18 August 2017

This application has been prepared by Ethos Urban (formerly JBA) on behalf of the University of New South Wales (UNSW), pursuant to Section 96(1A) of the *Environmental Planning and Assessment Act, 1979* (EP&A Act) to modify Development Consent SSD 7518 relating to the Science and Engineering Building at the UNSW Kensington Campus (the site).

The modification relates to the inclusion of a new mezzanine floor above the goods store area at ground level, in addition to the extension of a lift core through the podium slab of the double height basement / lower ground level which contains the IO Myers Theatre and Studio 1.

DRAWING NUMBER
A06 1001-SSD
REVISION
2

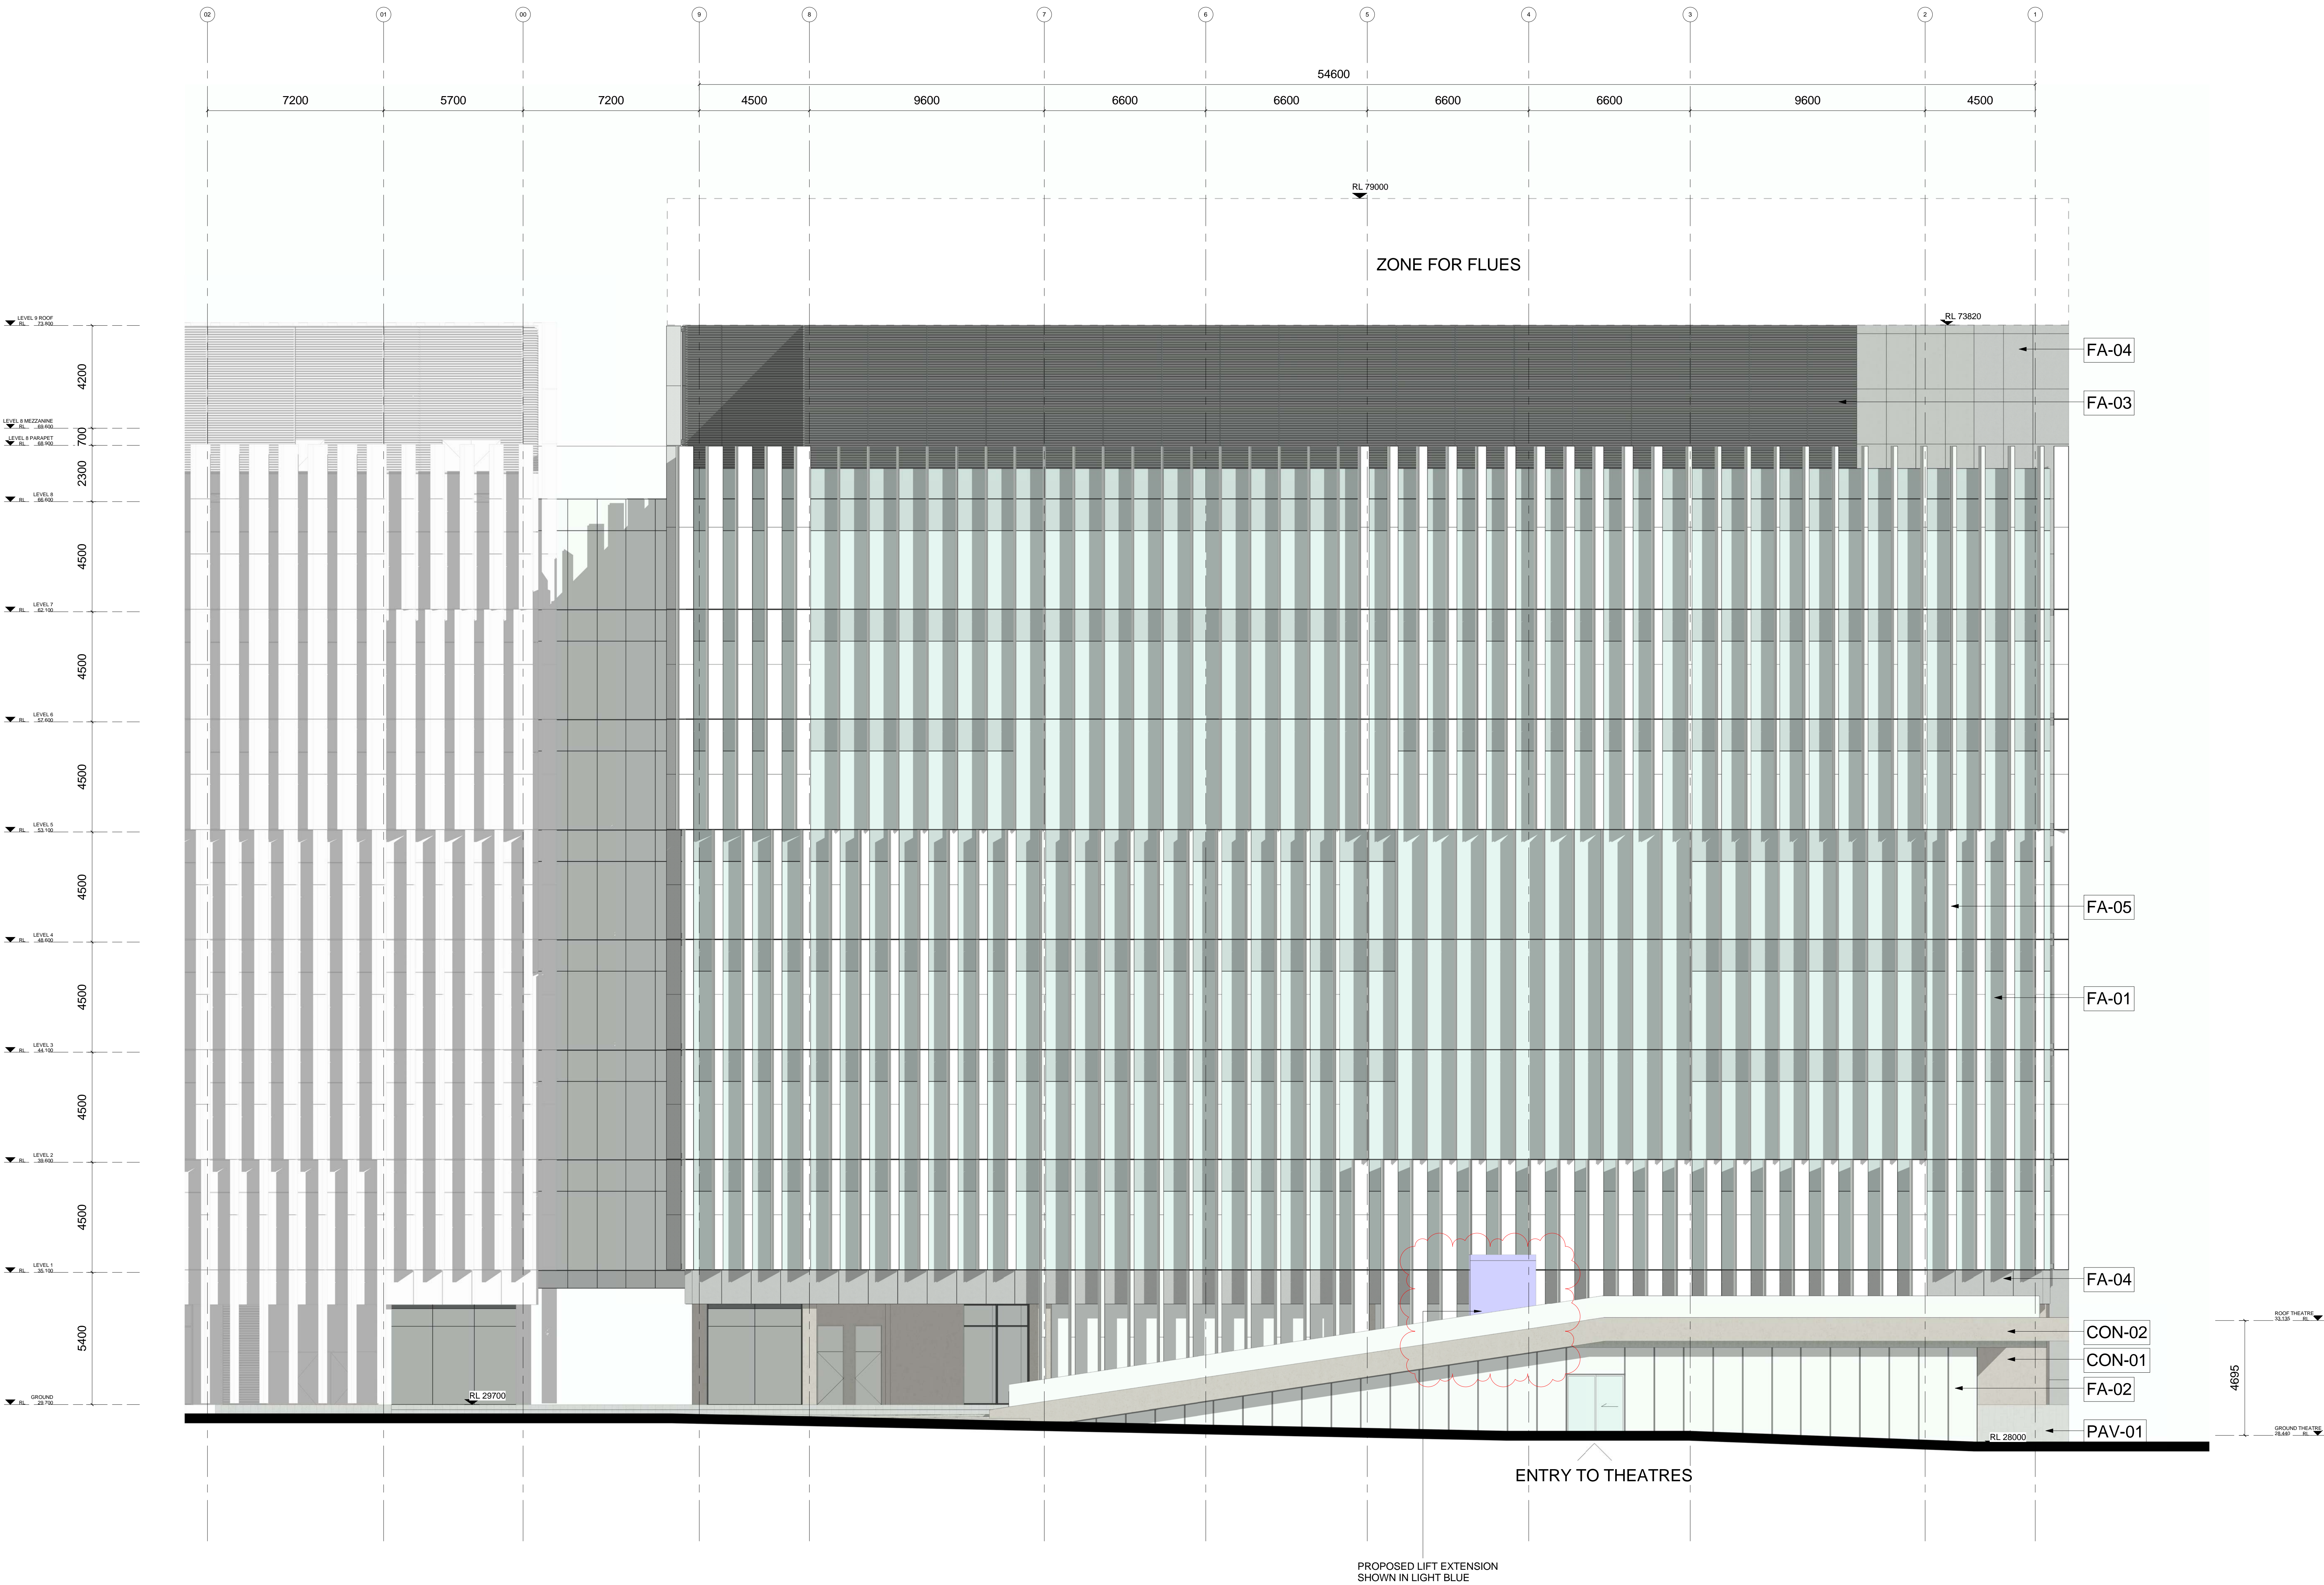
It is proposed to extend the approved lift core in the north of the lower ground / basement level (located between the IO Myers Theatre and Studio 1) through the podium slab. This lift services the IO Myers Theatre, Studio 1 and the foyer. The extended lift core will protrude to RL35.1, which is 1.96m above the current maximum height of the terraced podium (refer to **Figure 1**).

DRAWING NUMBER
A23 1002 C-SSD -
REVISION
1

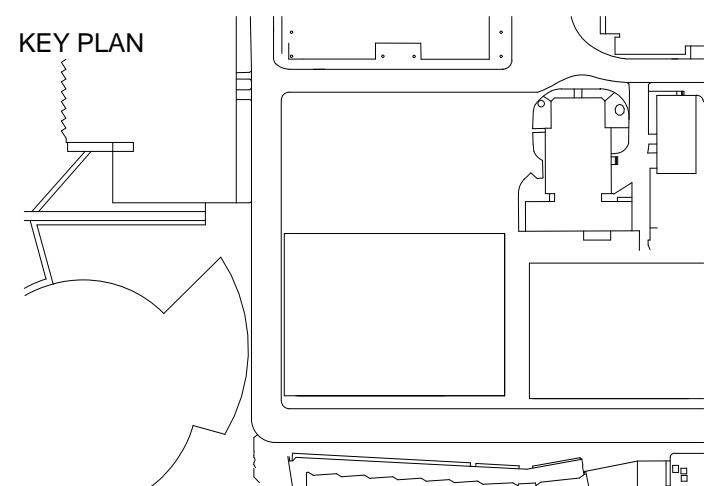
Under the approved design, the height of the ground floor is 6.82m. This has provided the opportunity for the inclusion of a mezzanine floor above the goods store area at ground level, without the need to modify any additional floor heights. This mezzanine will be 3.28m above the ground floor and will be used for consumables storage including items such as paper, glassware, basic equipment, stationary and other lab consumables. It will not be used for storing any hazardous materials.

The inclusion of this mezzanine floor will result in a GFA increase of 473m². The proposed mezzanine will not result in any changes to the exterior of the building.
